From: Martyn White <Martyn.White@arun.gov.uk> **On Behalf Of** Conservation Officer
Sent: 16 June 2026 17:19
To: Planning.Responses <Planning.Responses@arun.gov.uk>
Cc: Harry Chalk <Harry.Chalk@arun.gov.uk>
Subject: LU/102/26/L

LU/102/26/L

Address: Court Wick Park Courtwick Lane Littlehampton BN17 7PD

Proposal: Listed building consent for internal and external alterations to building to facilitate conversion and change of use to a children's care home, reinforcement of brick and flint garden wall with buttresses and reconsolidate wall with coping courses.

Detail 3 - New timber framed sash windows - Section

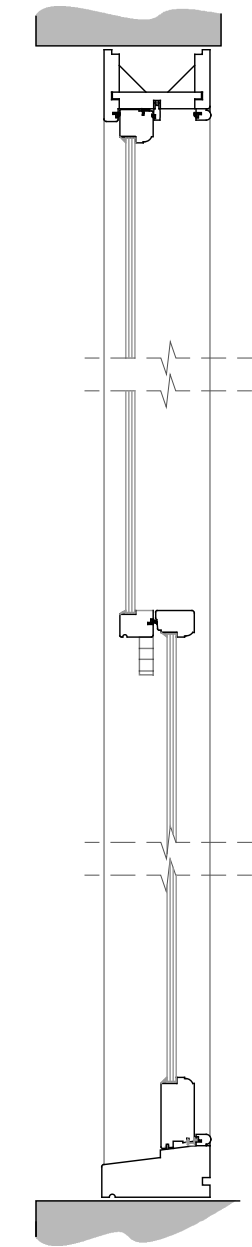
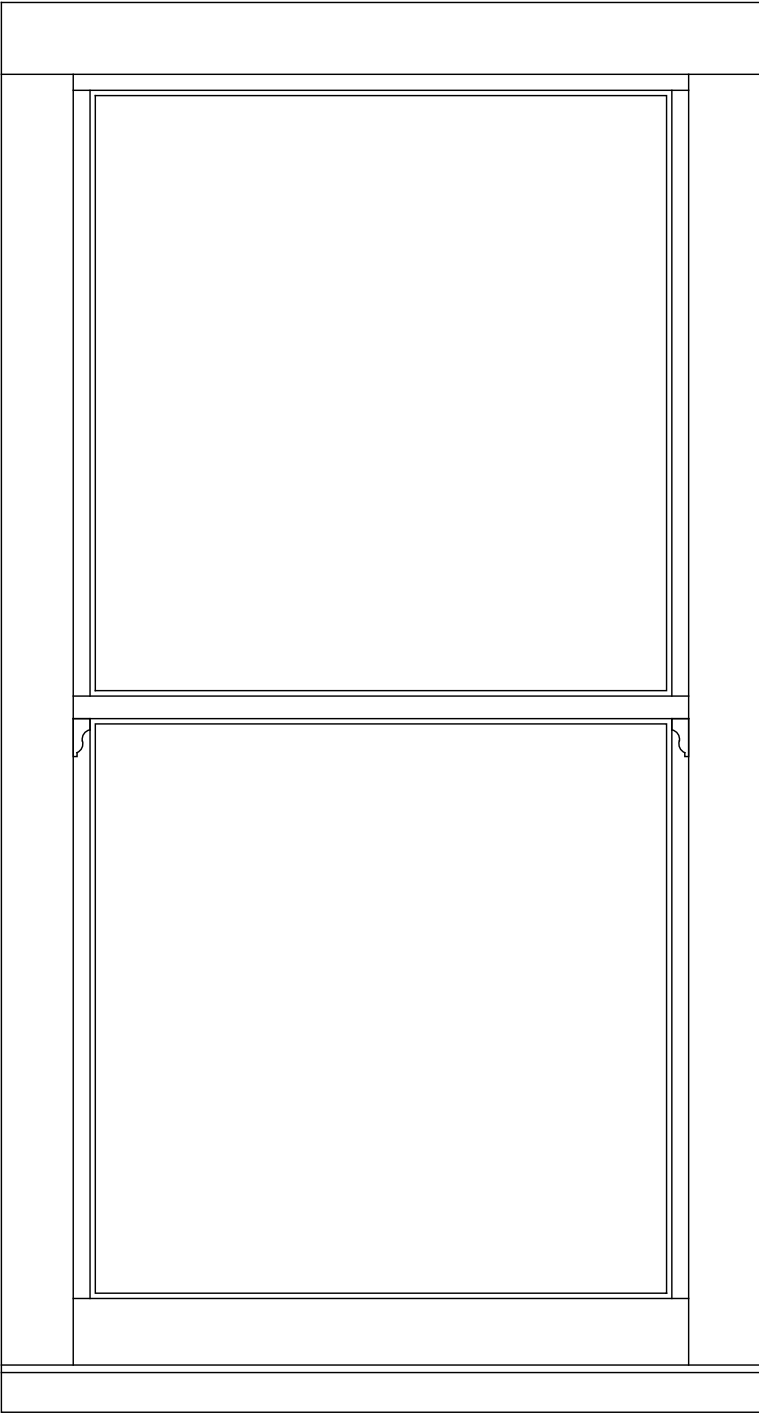
Whilst the external works are generally positive, it is disappointing to note the intention to replace the existing uPVC windows with new uPVC units. Reference is made to an alleged agreement to uPVC windows at a meeting; however, I do not recall this and would not support the use of uPVC within the historic environment, particularly within a listed building. The continued use of such windows is considered harmful to the significance of the heritage asset and cannot be supported. The windows should instead be replaced with appropriate timber equivalents, and the submitted drawings amended accordingly.

It is noted that the replacement of glazing within the existing timber windows with slimline double glazing is proposed, which would allow for the retention of the existing frames. However, no detailed sections of these windows have been provided, and further information is therefore required.
